Appendix A – Response to DPHI RFI

Table 1 Response to matters raised by Department of Planning, Housing and Infrastructure (DPHI)

1 ENVELOPE PLAN - GROUND FLOOR & BELOW
 1 : 200

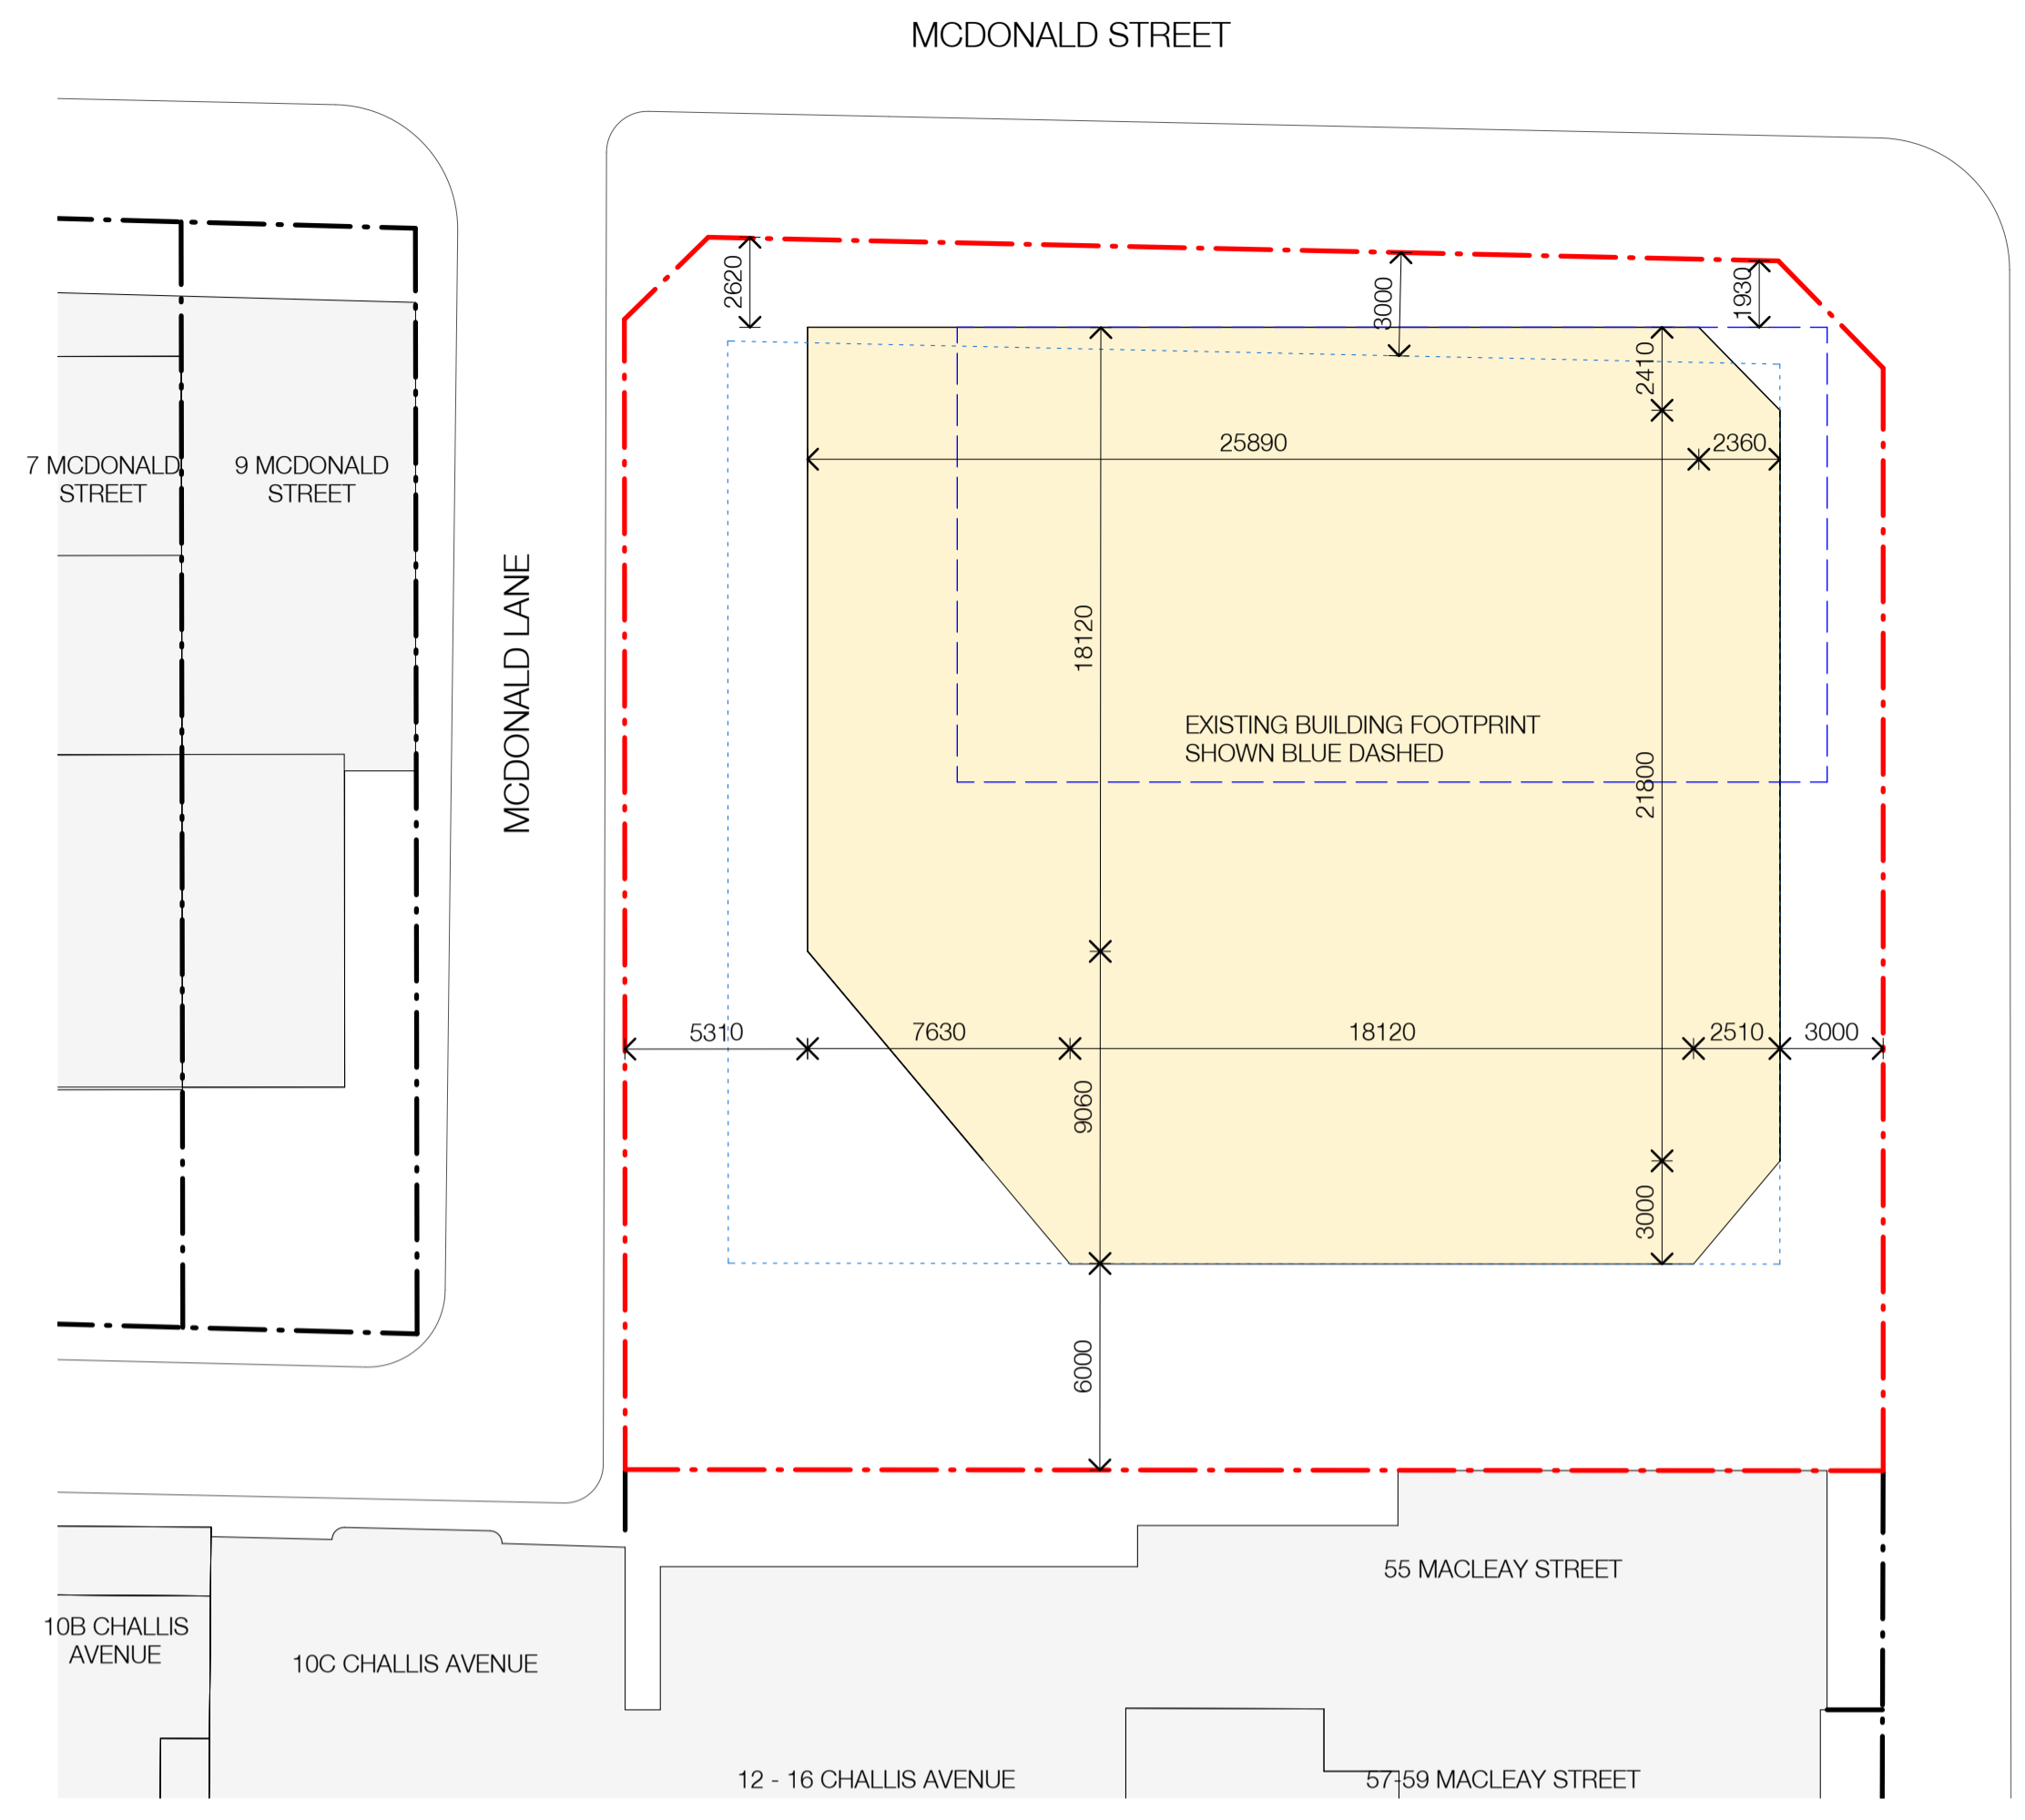
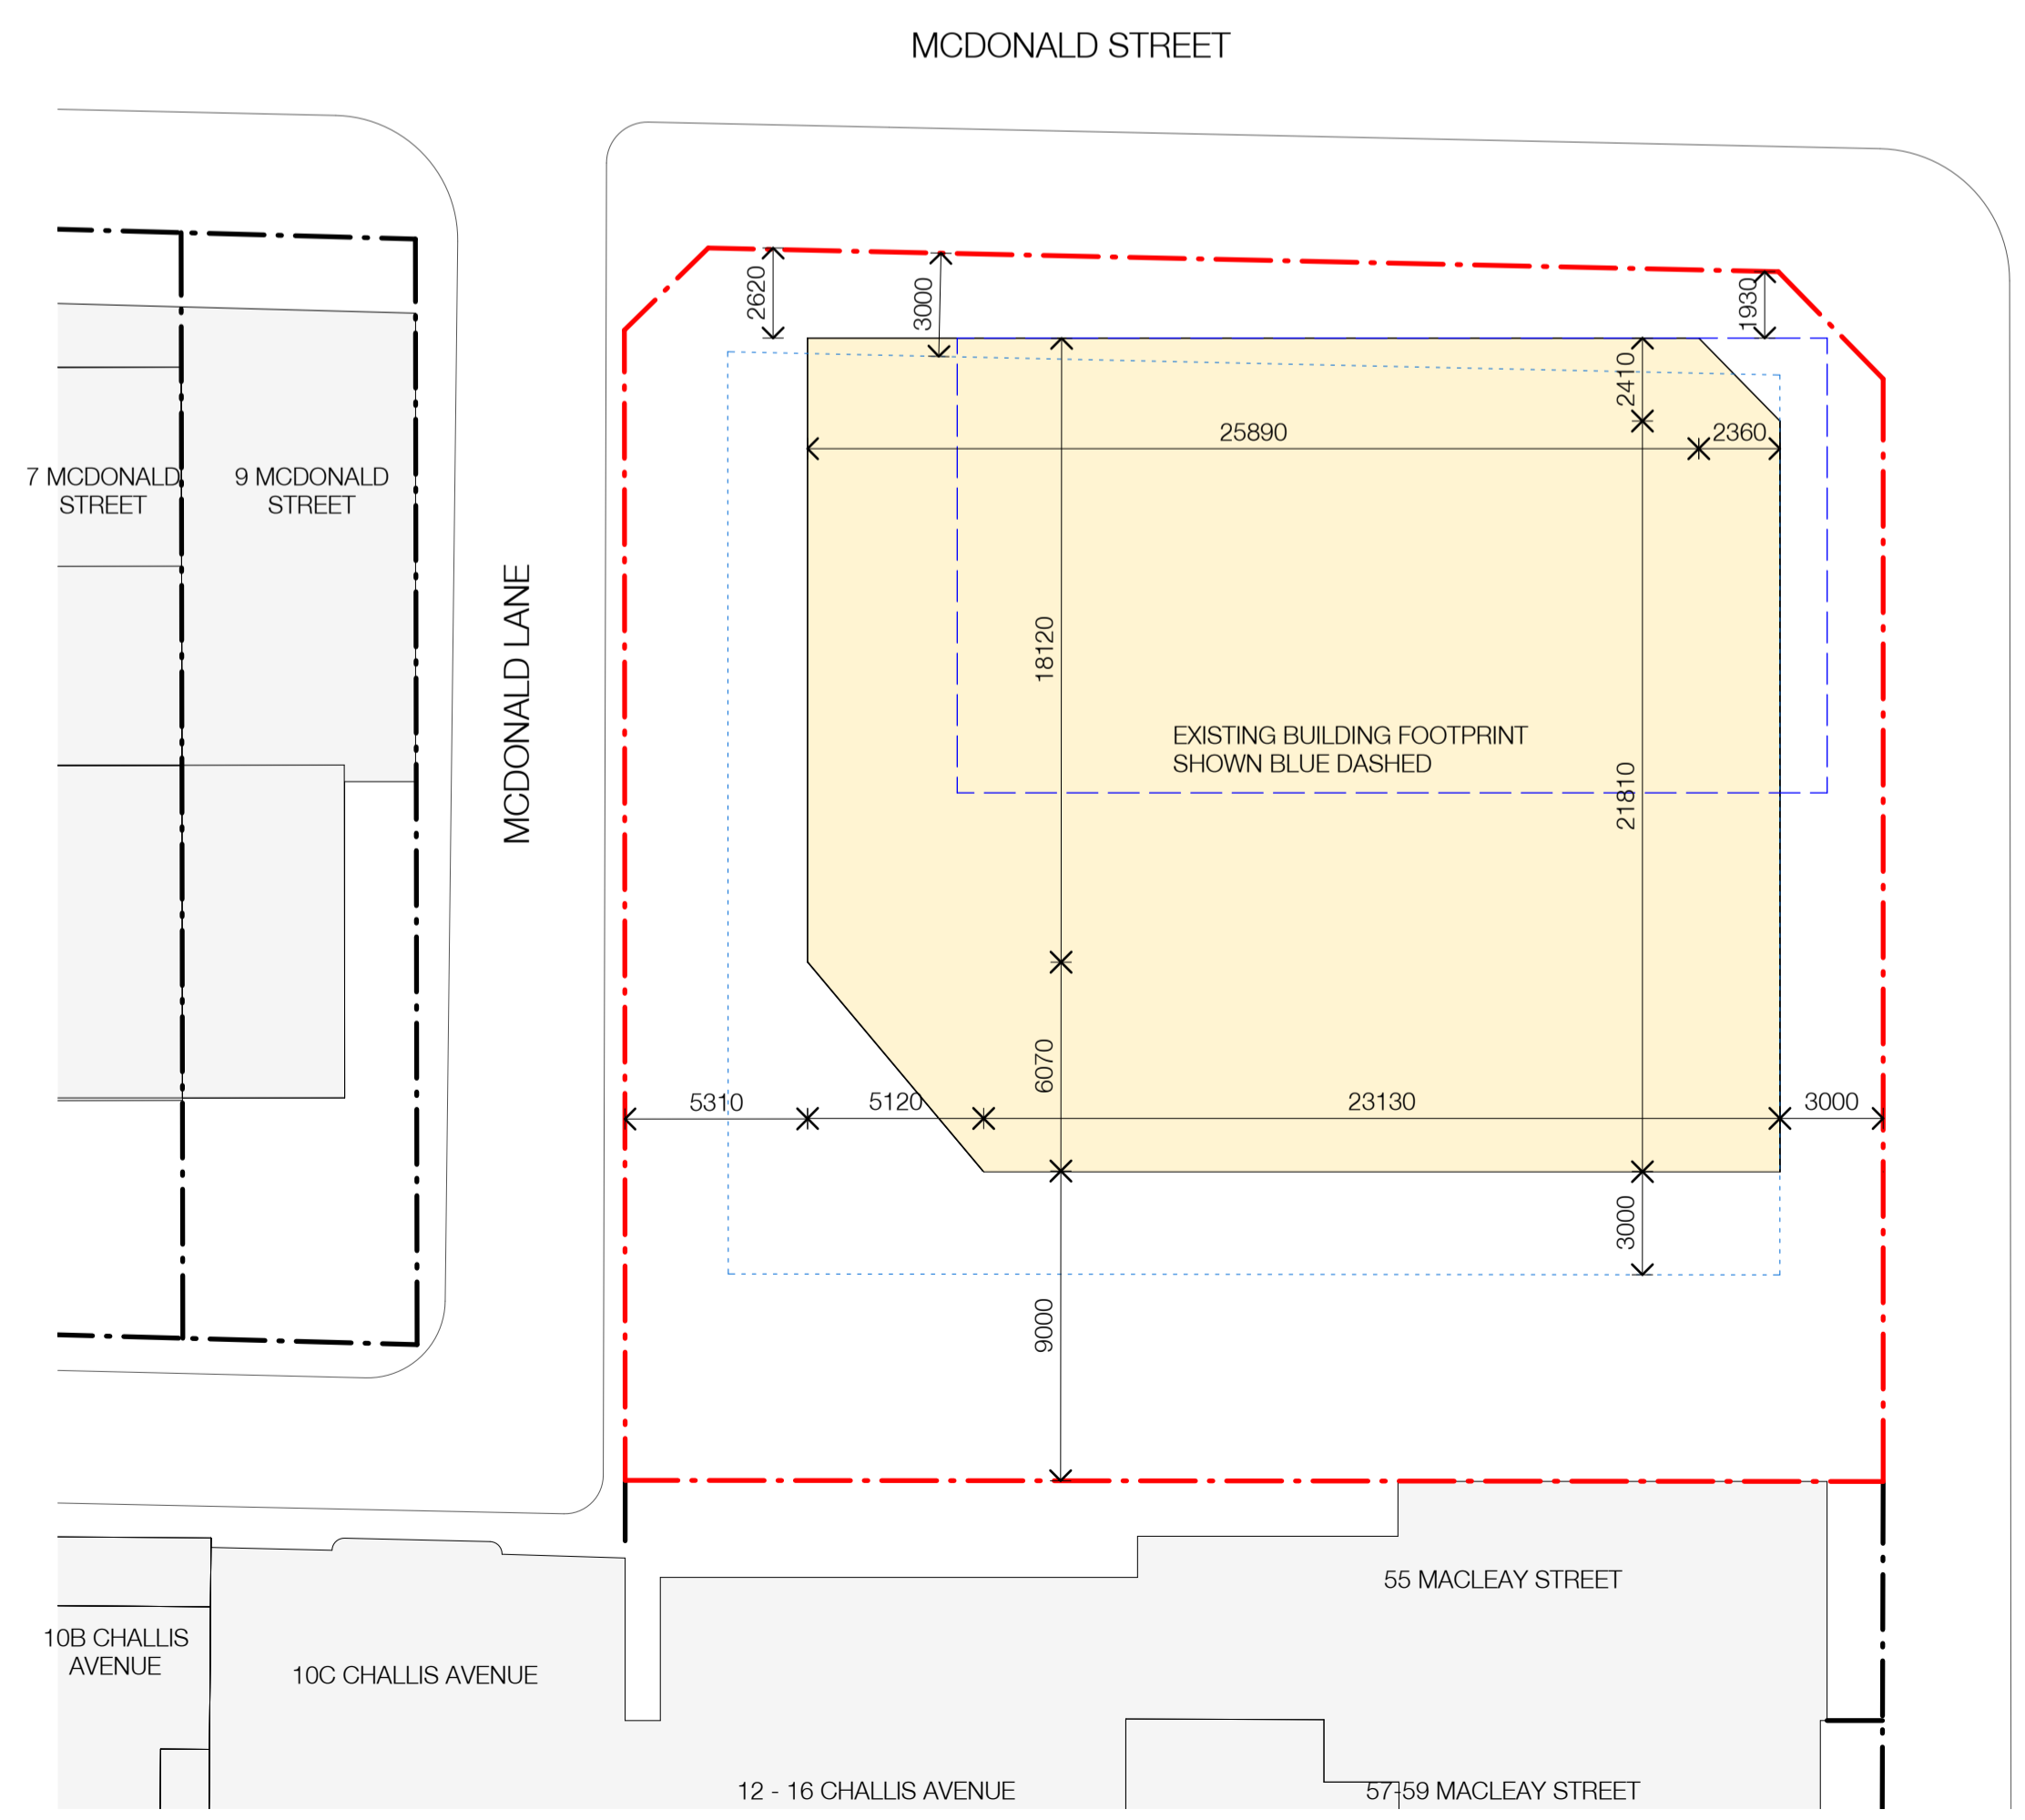
(b) Indicate the location and area of deep soil zones on the site plan.	The deep soil zone is proposed to be located along McDonald Lane and has been depicted in the updated Site Plan at Appendix B.	Appendix B
(c) Align the basement setbacks between the site plans and elevations. Specifically, the 2m eastern setback and the 3.8m western setback to the basement depicted on the site plan are not accurately depicted on the elevations.	The envelope elevation plans have been updated to show the basement setbacks at Appendix B.	Appendix B
(d) Detail the street names/frontages on the height plan diagrams.	Amended height plane diagrams containing street names have been provided at Appendix B.	Appendix B
